WILKINS ENGINEERING, P.C.

August 29, 2023

SUBJECT: Masonry Basement Wall Construction
145 Alice Holleman Lane
Fuquay Varina, North Carolina
Permit #SFD2303-0023

I am writing to address construction of the concrete masonry block foundation wall. My findings and recommendations are outlined below.

FOUNDATION PLAN-BASEMENT
Scale: 3/16" = 1'-0"

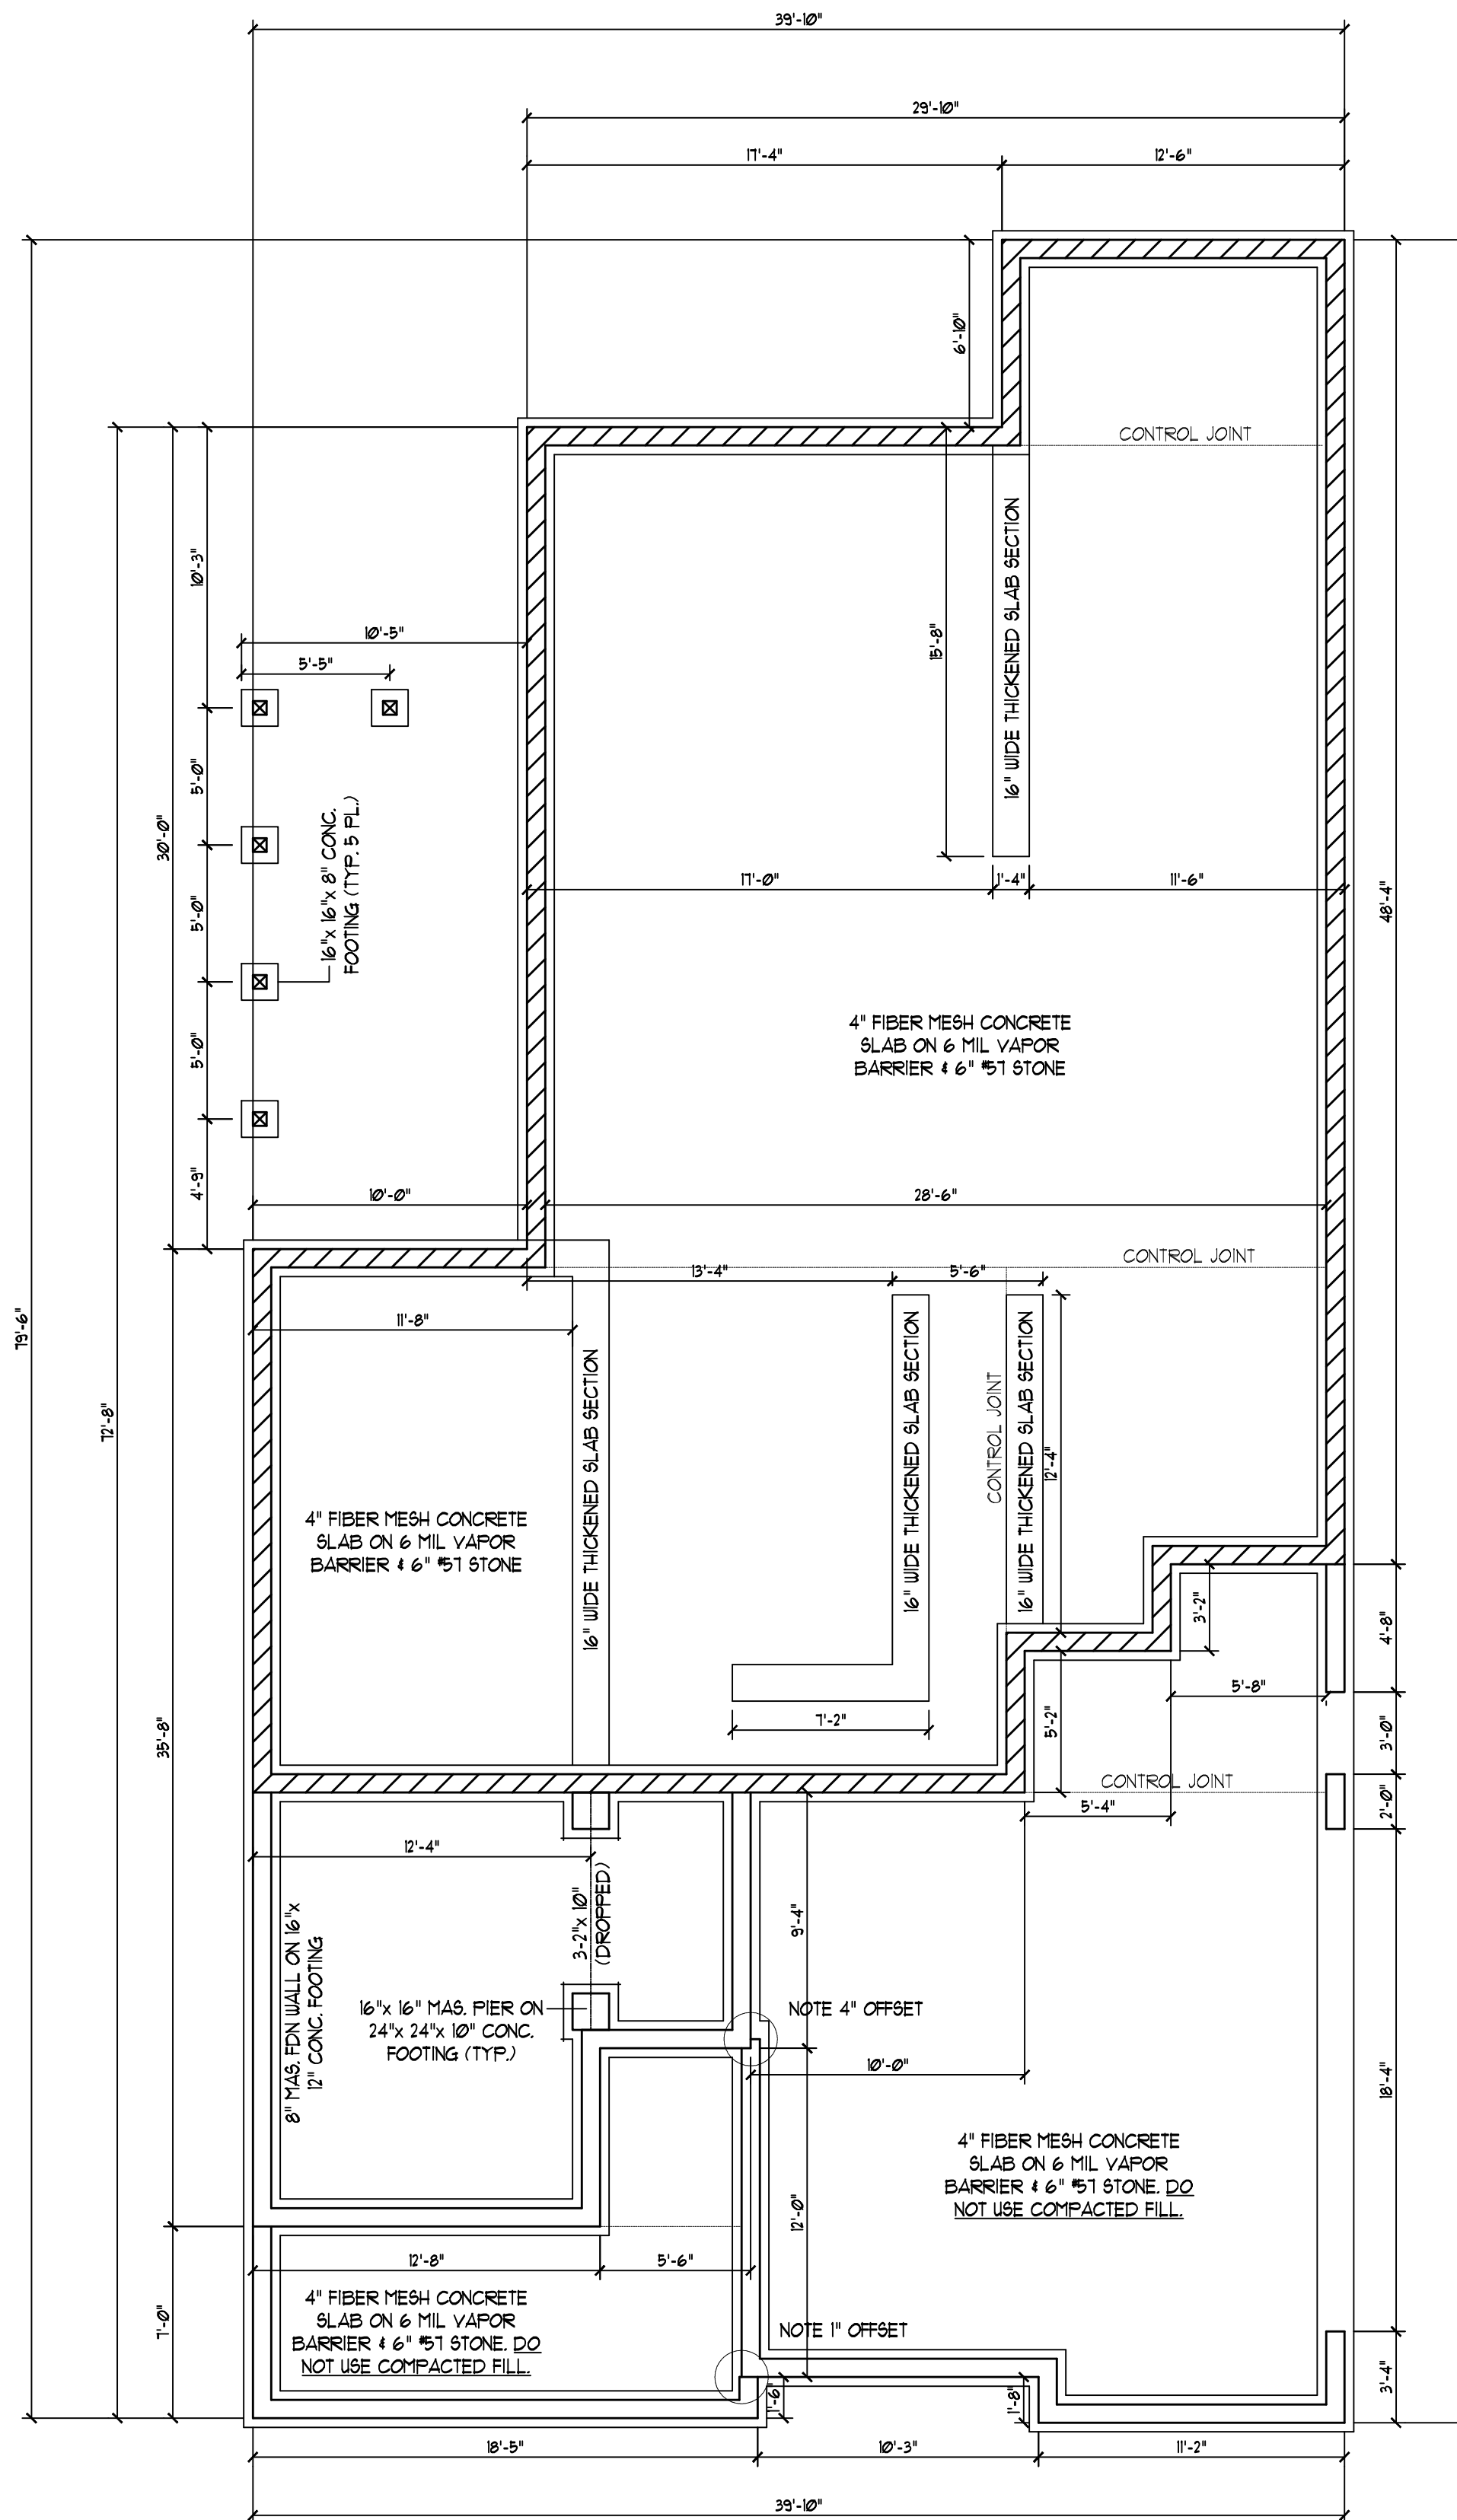
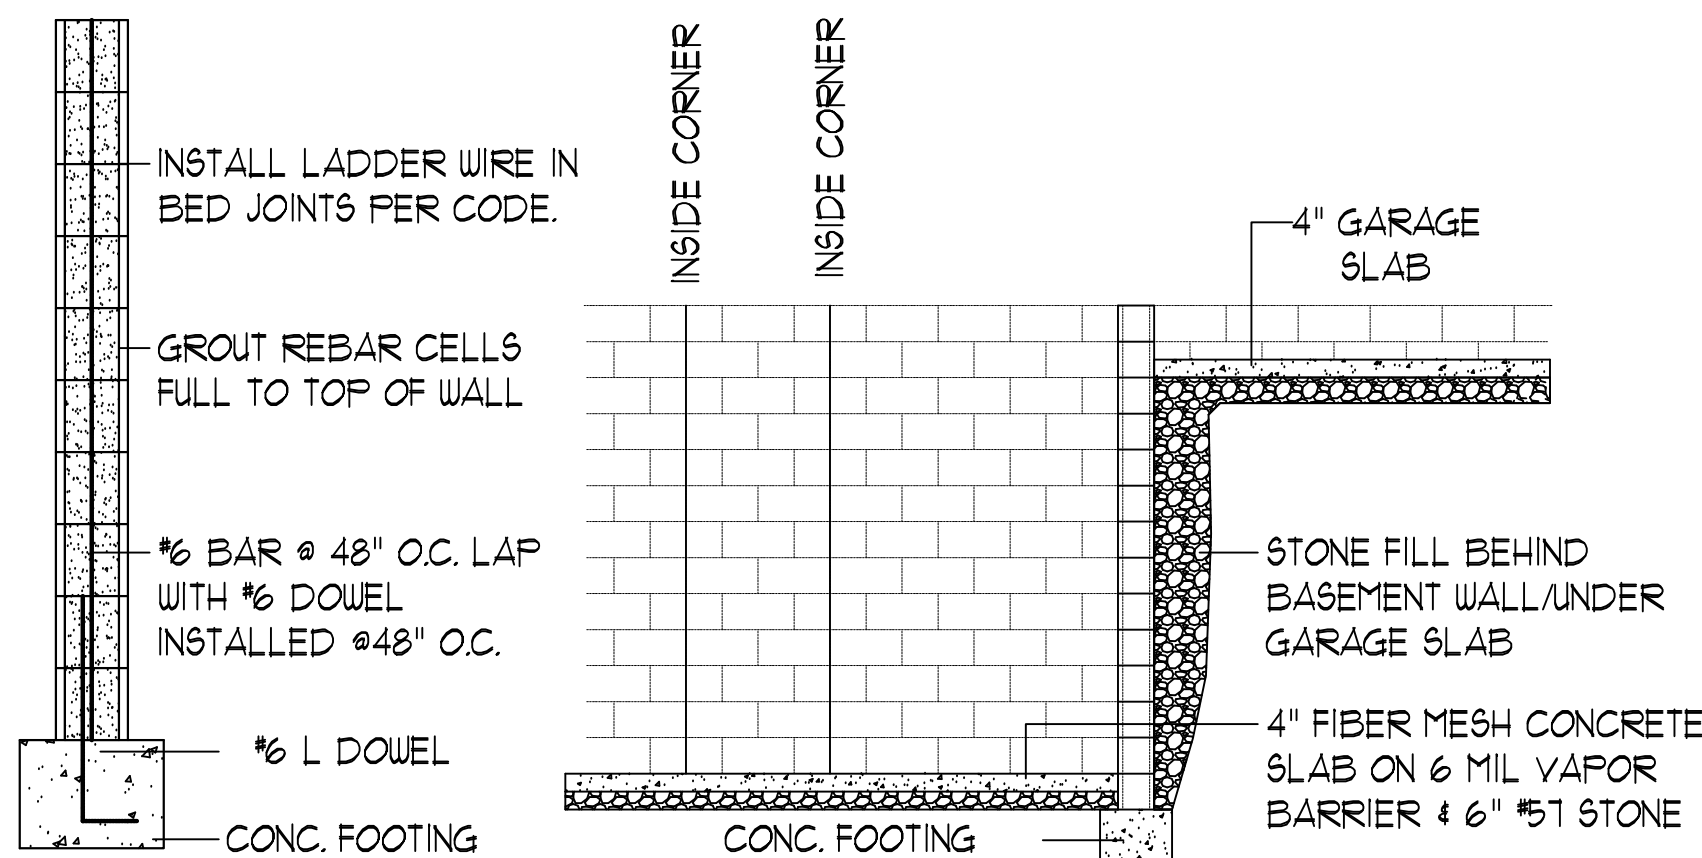
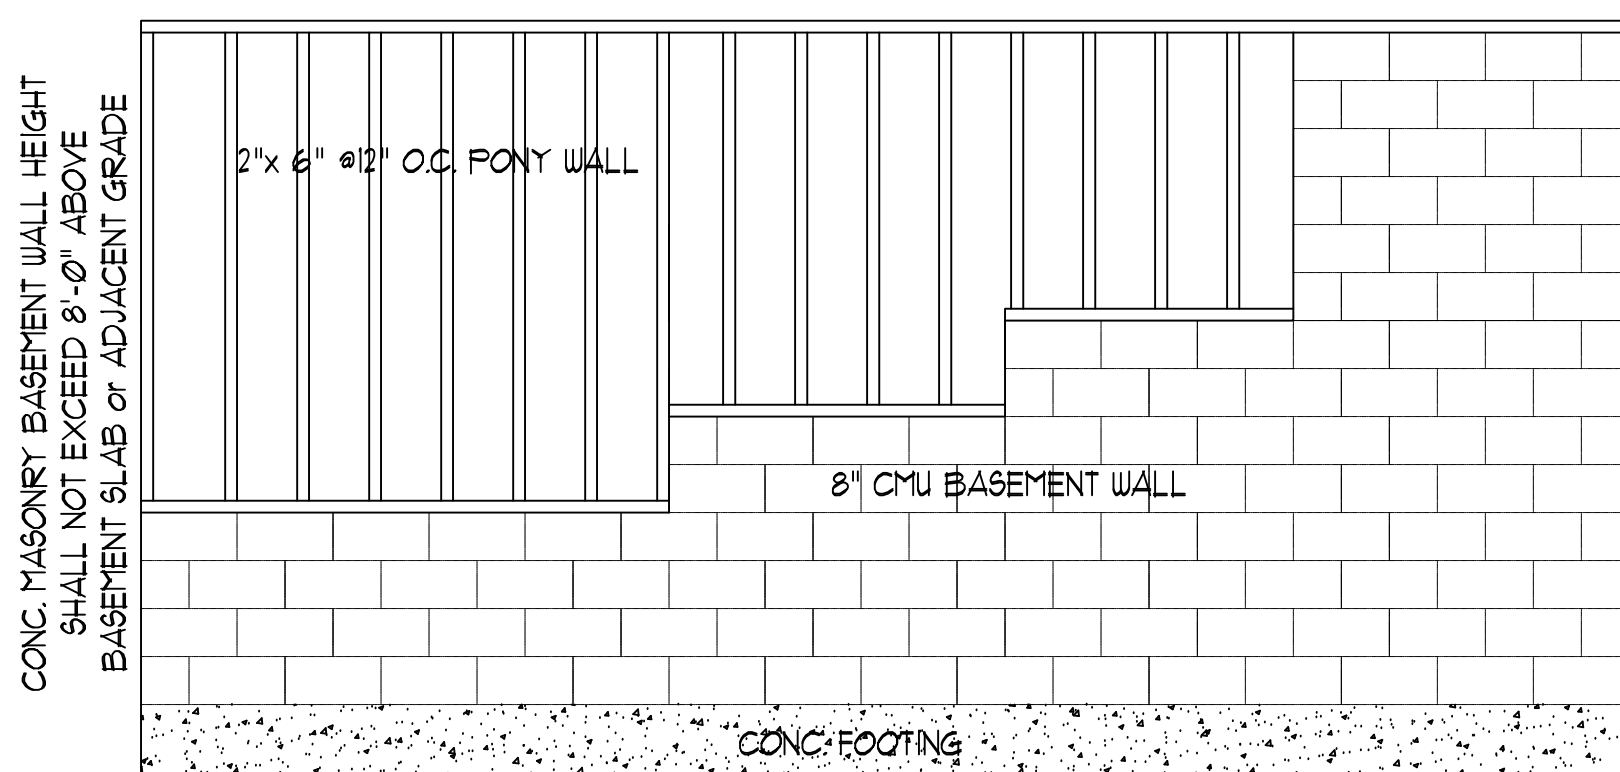
The original design drawings called for construction of a CMU basement wall with a height not to exceed 8'-0". The constructed basement wall actually has a height approximately 11'-0" above the proposed basement concrete slab. The basement wall section between the front crawl space as well as the wall section along the back of the proposed garage slab was actually constructed of 12" CMU/concrete block which is vertically reinforced with #6 reinforcing bars with the cells filled at 48" on center. Additionally, the subject wall was constructed with horizontal joint reinforcement in accordance with the requirements of the 2018 NC Residential Building Code. Accordingly, I find the height of the basement wall as constructed to be structurally acceptable and floor framing over the basement wall should proceed before fill material is placed on the outside of the basement wall. No modification or remedial action is required and construction of the first level floor framing should proceed as soon as possible.
